BR/242/21/OUT

Land rear of 94-100 Hook Lane Bognor Regis PO22 8AT

Outline application with all matters reserved except access for the demolition of existing bungalow to form new access for 6 No. detached chalet dwellings (resubmission following BR/124/21/OUT).

Martyn White
Principal Conservation Officer,
Planning Services

2. **Sc** Figure 2: Indicative Proposals.

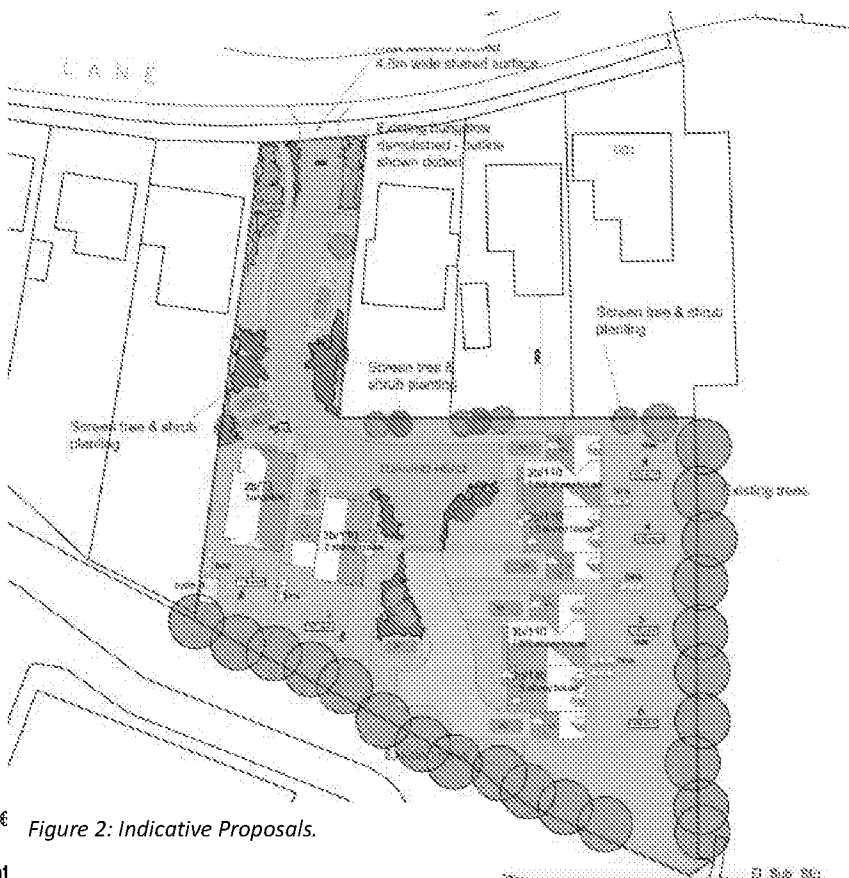
I note that a feasibility site plan has been submitted with the application which identifies that the new homes could be accommodated within the site without the loss of the boundary planting. However, I would want to be assured that the layout of the site can easily accommodate the number of houses proposed without the need for the trees to be altered or removed either as part of the detailed planning application or at some point in the future due to issues such as overshadowing etc. The loss or (part) removal of the trees would then expose the site along with the new development to the heritage assets, which would be harmful. Therefore, I am of the opinion that careful consideration should be made with regard to the capacity of the site and any potential layout.

Subject to my comments regarding the retention of the existing trees as part of a carefully considered layout, it is considered that development would not cause harm to the significance of the heritage assets/their setting. As a consequence, it should be determined in accordance with the relevant policies within the Development Plan, along with these comments. You will also need to take into account the contents of the Planning (Listed Buildings and Conservation Areas) Act 1990 (as amended).
